OUT18/14663

**Walla Walla Solar Farm (SSD-9874)
EIS Exhibition**

D.1.1 General Layout

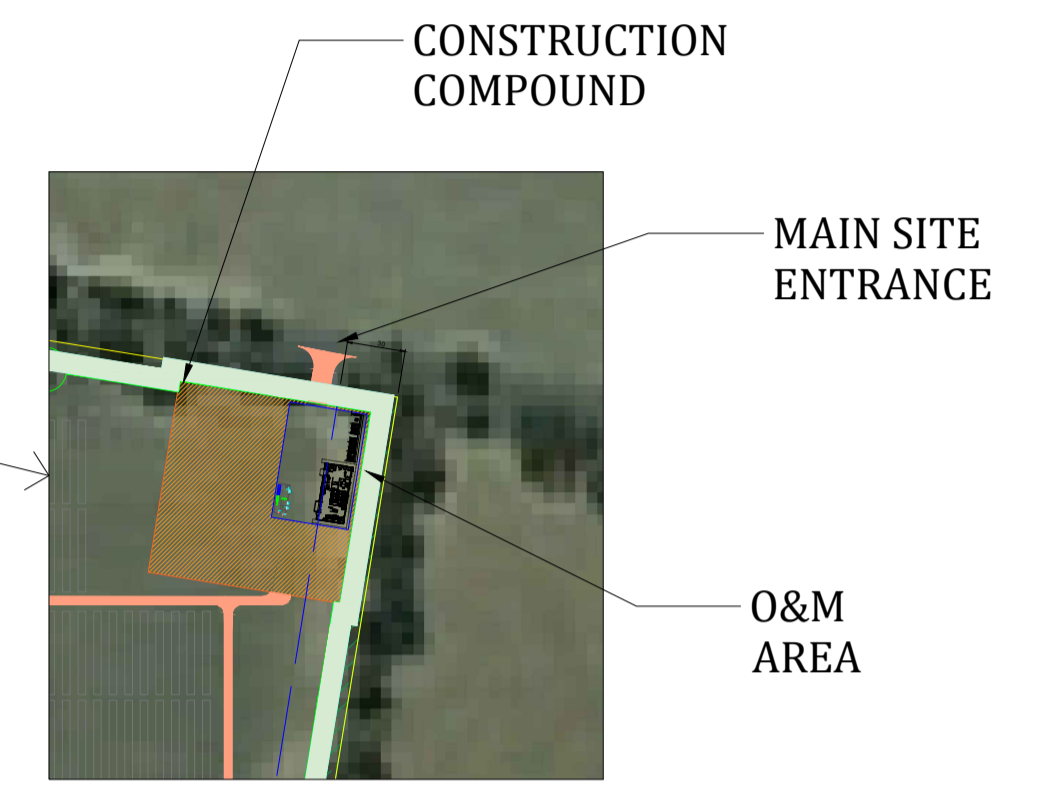
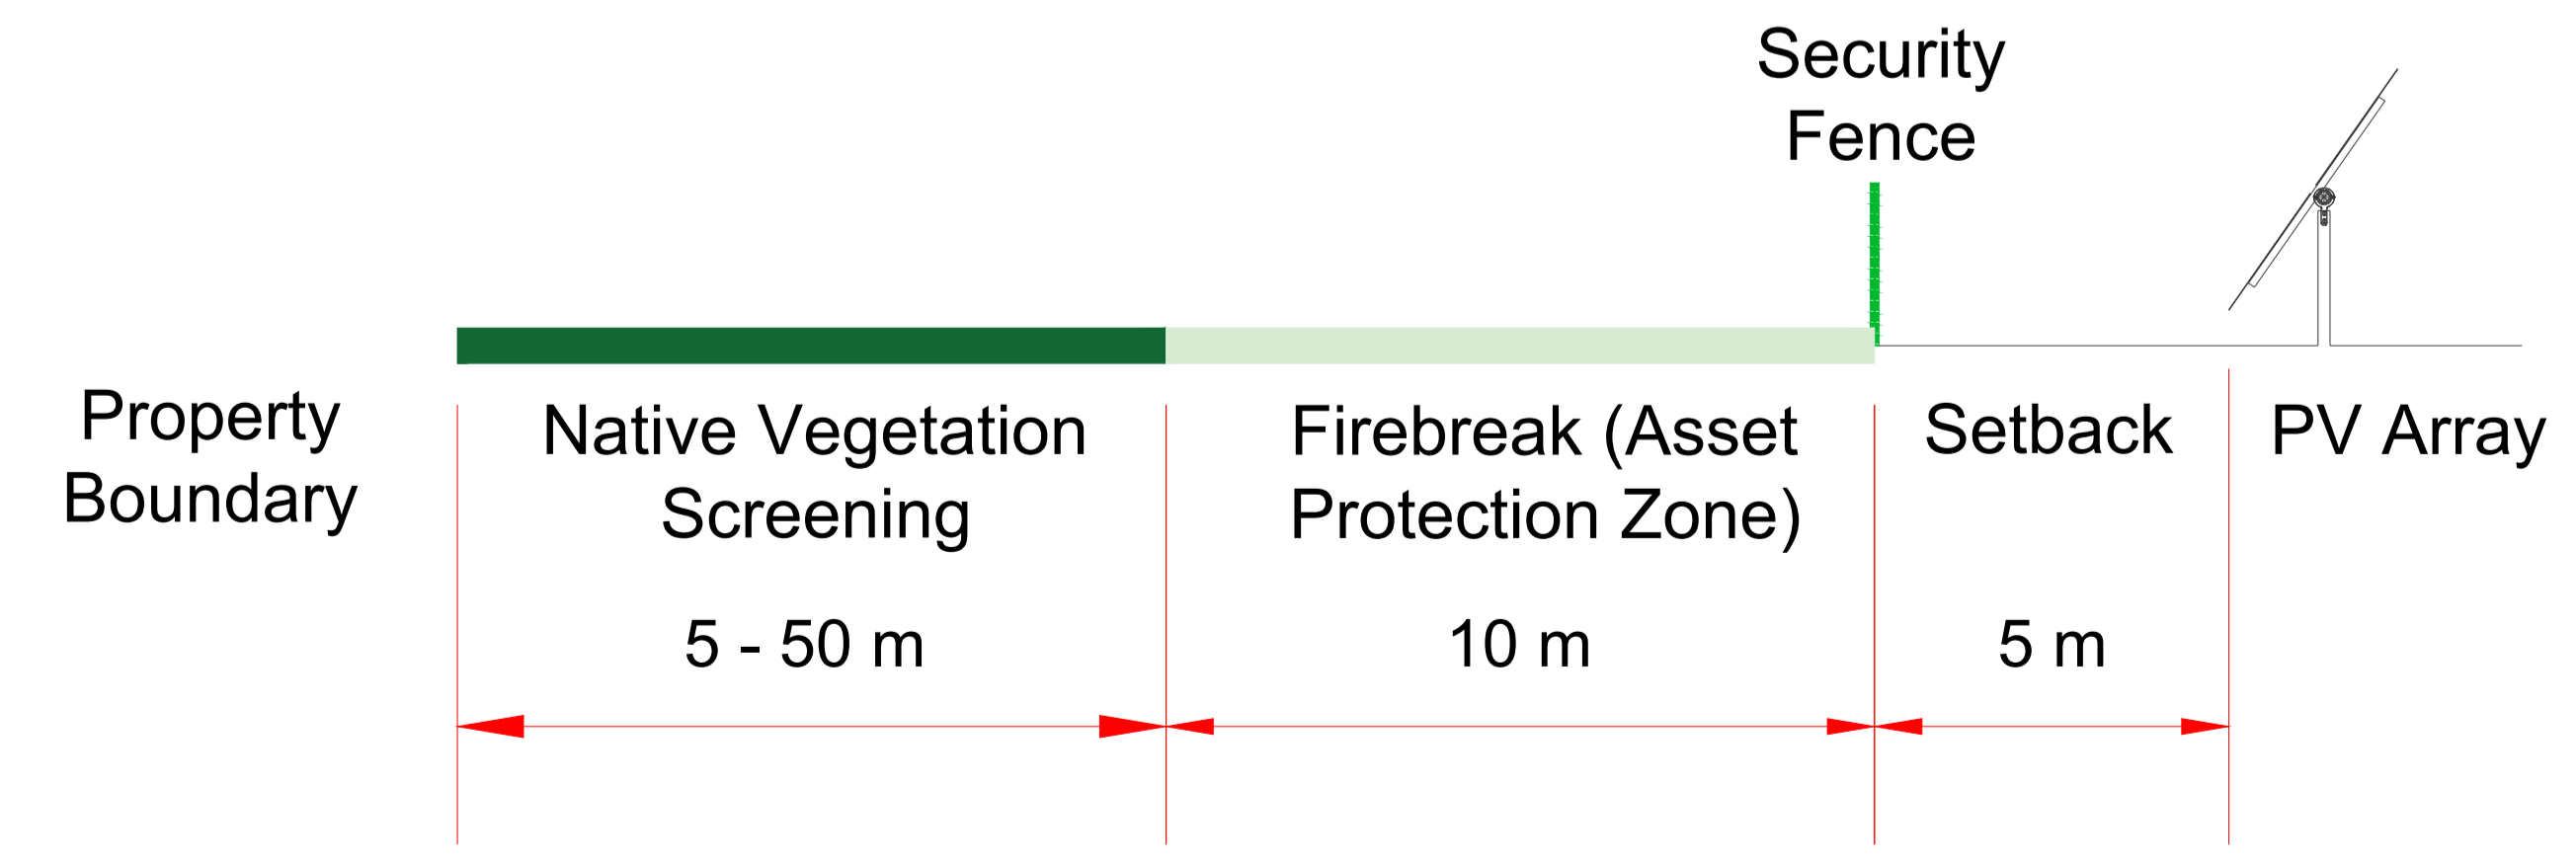
- Clarification should be provided of the proposed infrastructure layout to meet the buffer requirements from watercourses as defined in the *Guidelines for Controlled Activities on Waterfront Land* (NRAR 2018). This is to include a vegetated buffer for Middle Creek.

Indicative Fence Flood Gate

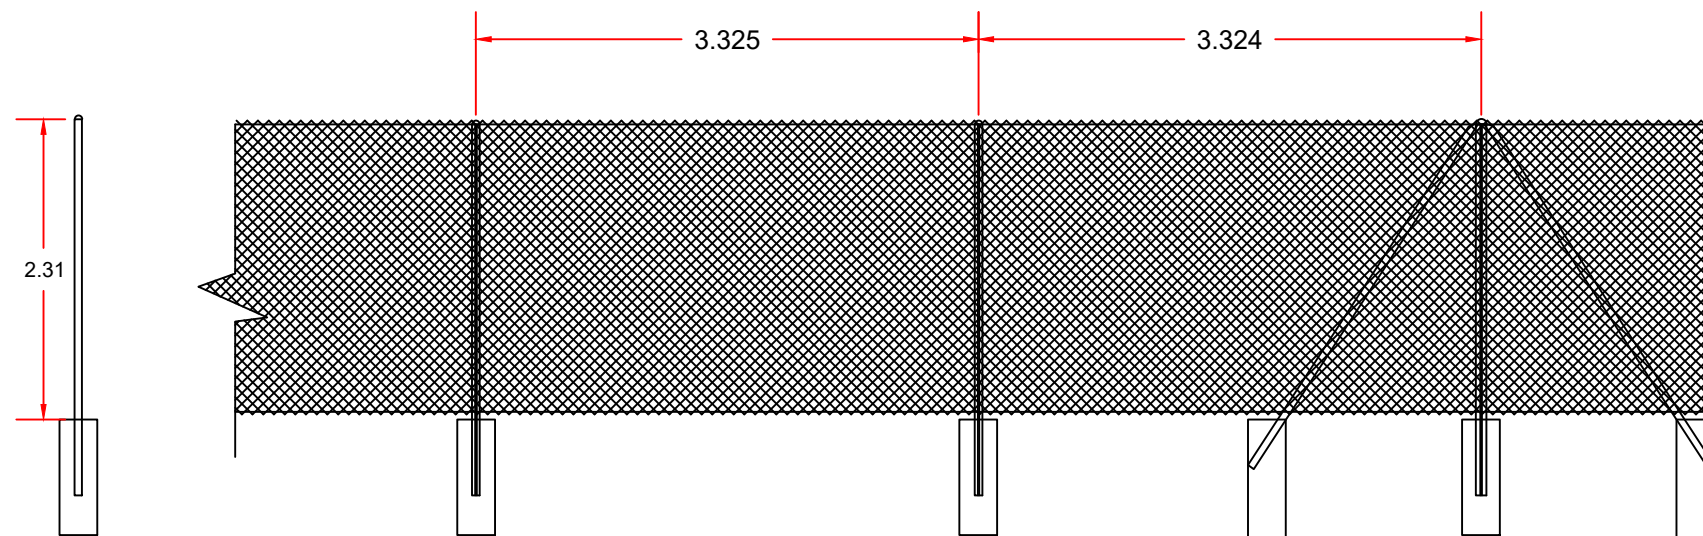
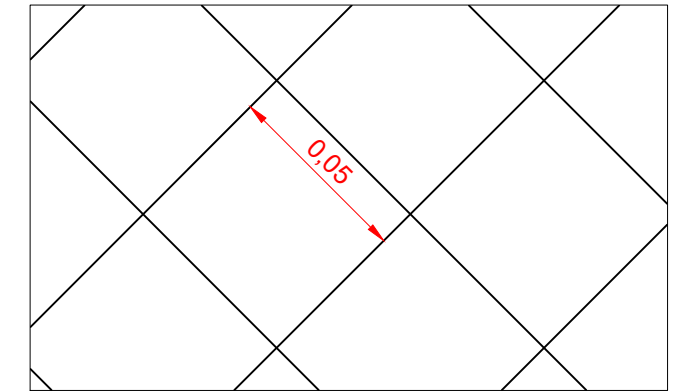
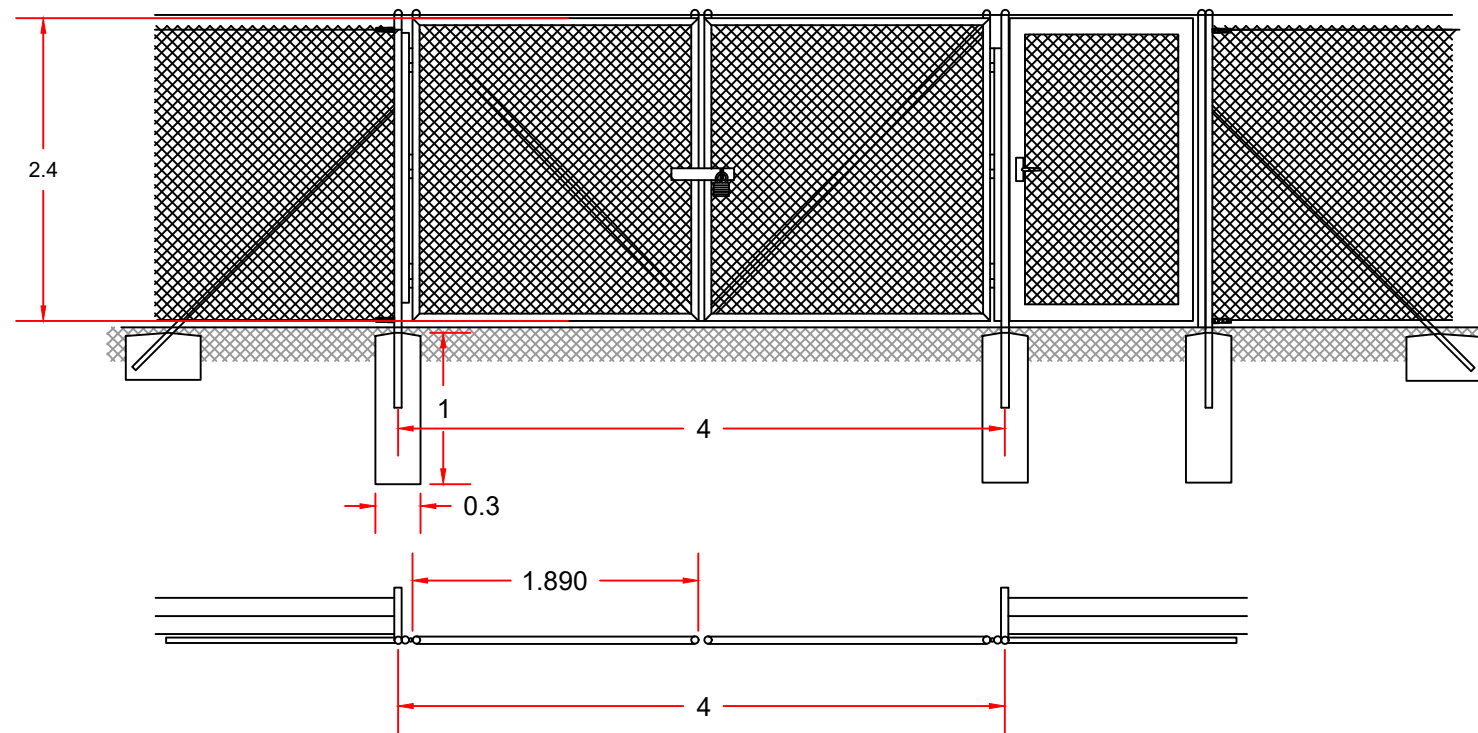
- The proponent should confirm the impact of the security fencing on floodwaters and the resultant impact to adjacent watercourses.
- Landscape maps in Appendix E should specifically note the minimum riparian corridor widths in accordance with *Guidelines for riparian corridors on waterfront land*.
